From: James Thompson [REDACTED]
Sent: 25 October 2019 15:14
To: Planning <Planning@arun.gov.uk>
Cc: Adam King [REDACTED]
Subject: A/146/19/PL - Revised Planning Drawing

Further to our telephone conversation please see attached the revised planning drawing for the purposes of validating the application for Land rear of 1 The Heathers, Arundel Road, Angmering.

P3	25.10.19	Revised notation.	JT	AK
P2	25.10.19	Revised red line and road name correction.	JT	AK
P1	17.10.19	Planning Issue.	JT	AK
Rev	Date	Revision Details	Dr	Ch

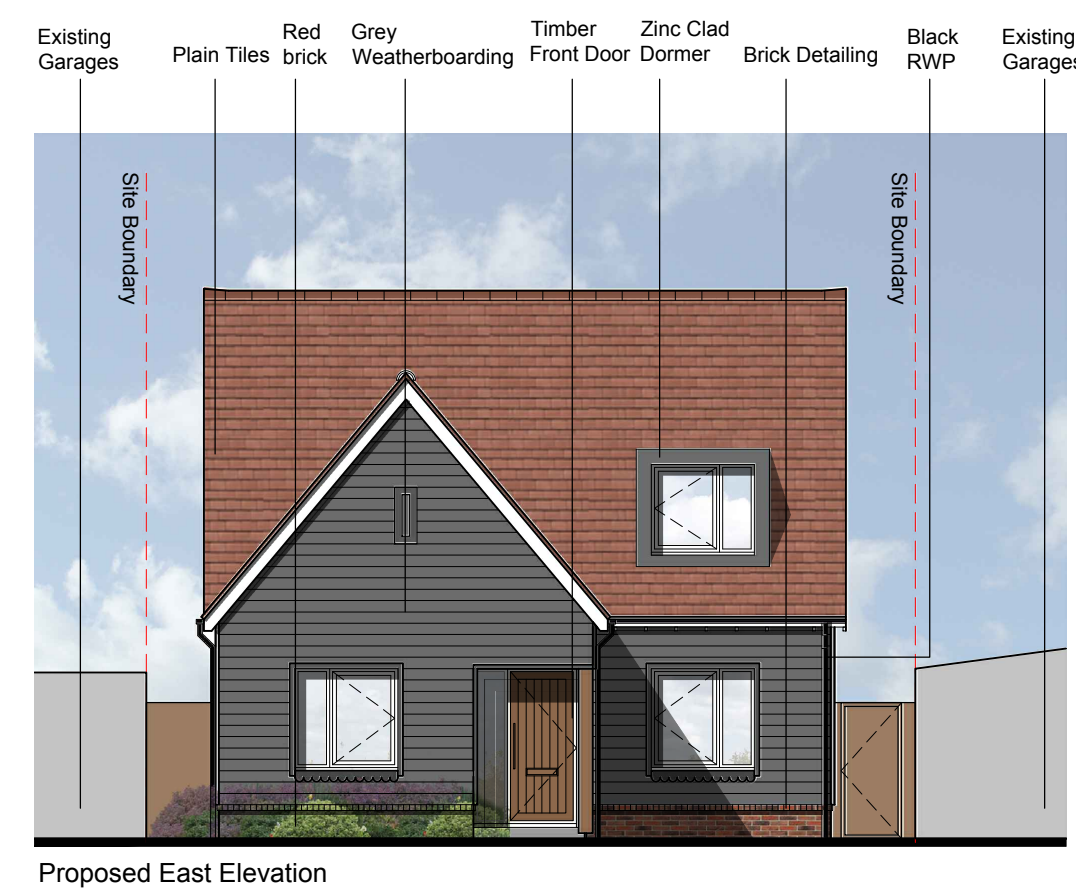
On the location plan, the named road is not correct. Please amend accordingly and provide another named road. Also, please clearly show the access to the site within the red edge. – As per our conversation, the google map and OS map ordered incorrectly stated the road as Lloyd Goring Close. As per your suggestion this has been changed to Claremont Close. Arundel Road and Lansdowne Way have now been added as additional road

On the block plan, the named road is not correct. Please amend accordingly. – Similarly, this has been amended as above.

names in the location and block plan. The access to the site from Lansdowne Way has also been included within the red line.
